OUT21/8080

McPhillamys Gold Project (SSD-9505)

Mitchell Isaacs
Chief Knowledge Officer
Department of Planning, Industry and Environment: Water
22 June 2021

Figure 3-1

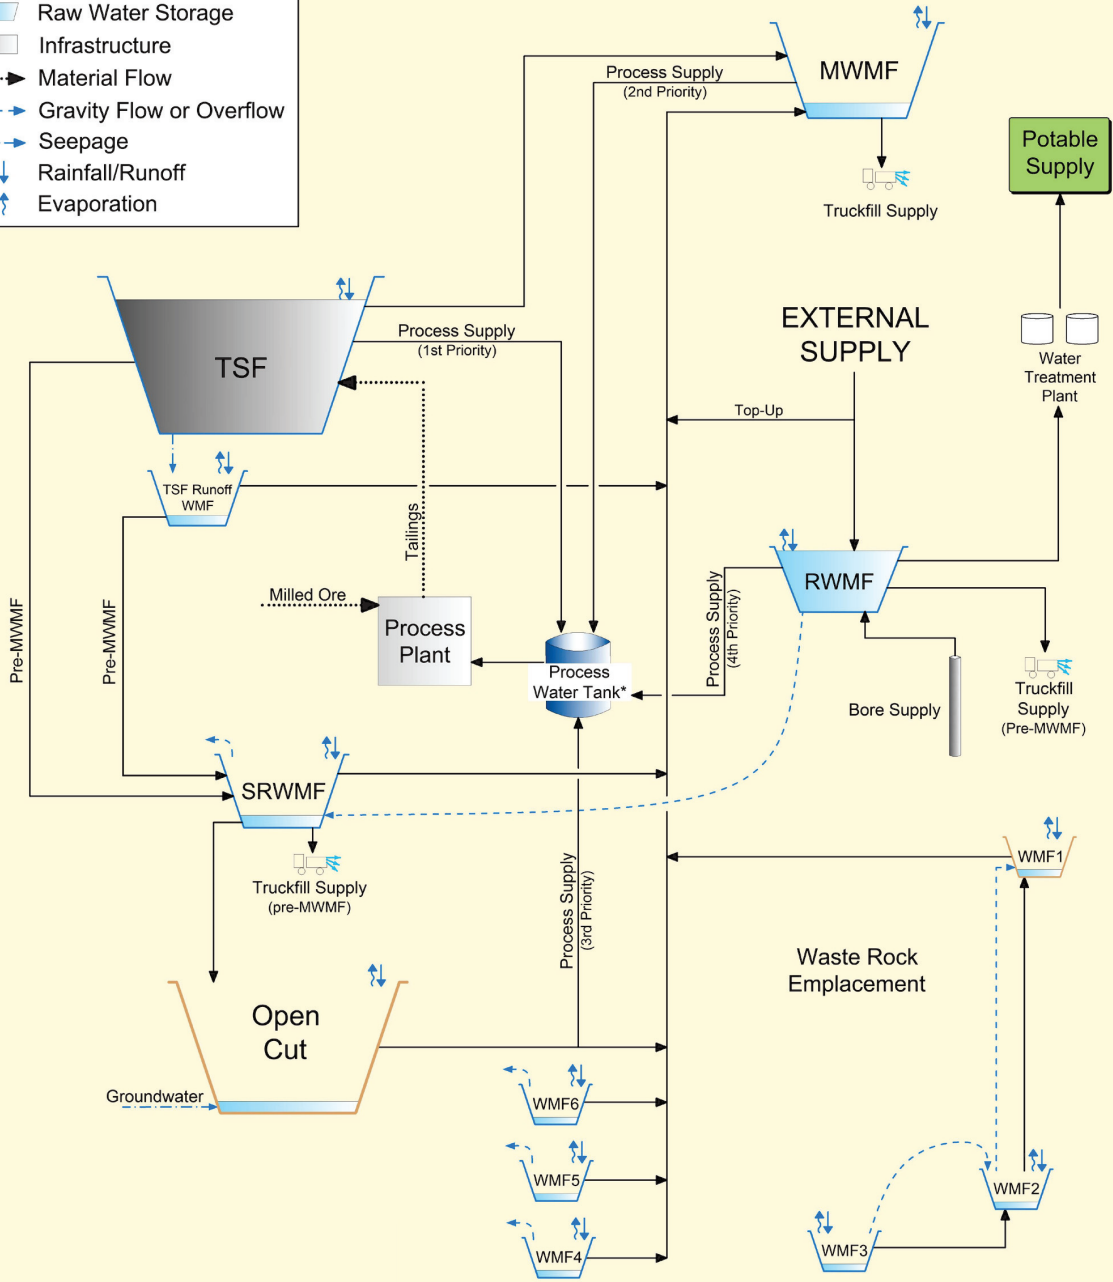
- The updated hydroline layer resulted in the dam walls of two storages (TSF and WMF6) being located on third or higher order watercourses and the remaining storages located on minor streams.
- Dams CWF1a, CWF1b, CWF2, CWF3, RWMF, MWMF would be located on minor streams, however do not appear to satisfy any of the exclusions for licence requirements under Schedule 1 of the *Water Management Regulation 2018*. This is due to the dams either capturing runoff from undisturbed areas or being constructed because of the project and hence not **solely** for the exclusion purposes (Sch. 1(3) and (4)) as required by the regulation.

In order to consider these structures as exempt the NRAR recommends that the proponent consider:

- Redesigning RWMF and MWMF to be turkeys nest dams with no catchment from undisturbed areas. Divert clean water around the site via diversions or in combination with appropriately sized clean water dams.
- Redesigning CWF1a and CWF1b to the minimum size necessary to enable the capture and diversion of clean runoff.
- Reviewing the design of WMF6 to ensure it is sized appropriately for the draining catchment and/or consider its relocation to minor streams.
